# CITY OF ALBUQUERQUE

**Re: LEGACY NAA APARTMENT, OAKLAND BETWEEN SAN PEDRO AND  
LOUISIANA, LOTS 4-10 & 23-29 BLOCK 28, TRACT A, UNIT B NORTH ALB ACES  
BUILDING 14 & 15**

**Transportation Development Final Inspection**

Engineer's/Architect's Stamp dated 11-18-16 (C18-D064B)

SITE PLAN  
PRELIMINARY

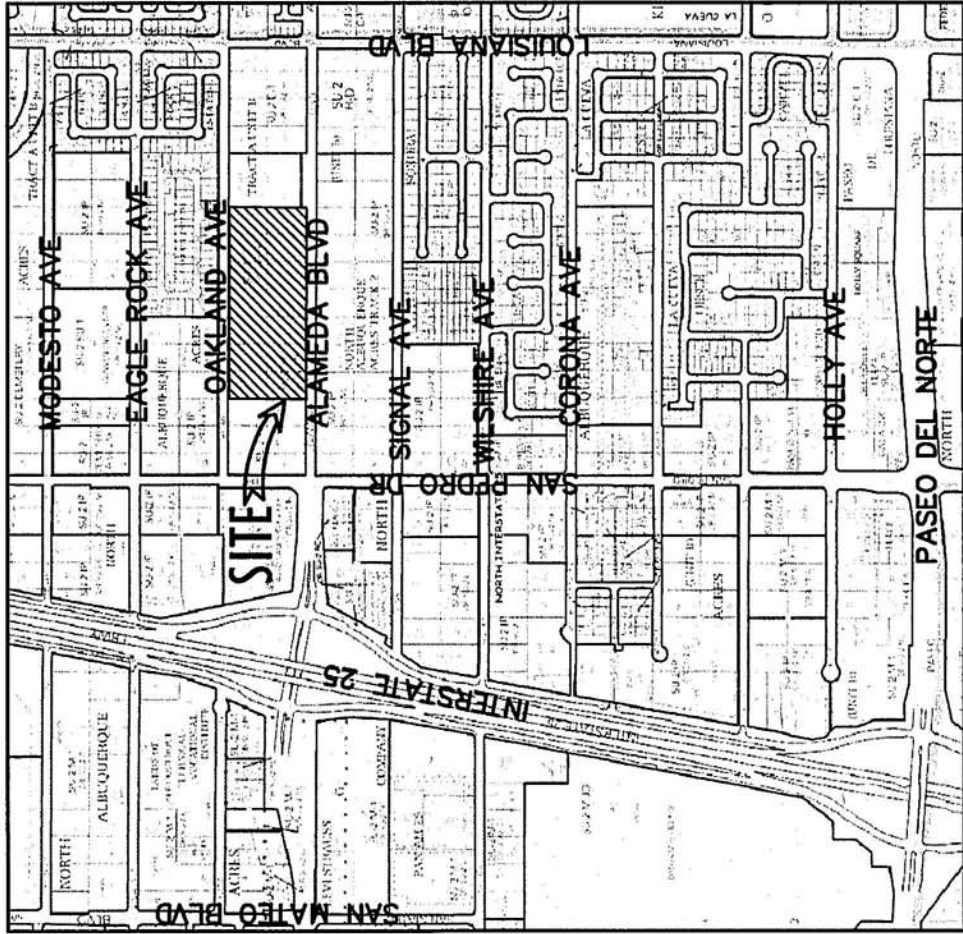
- All construction fencing and equipment must be removed from the site
- The number of parking spaces in front of the building #15 does not match the site plan. There are 11 spaces on site, but the drawing shows 12 spaces.
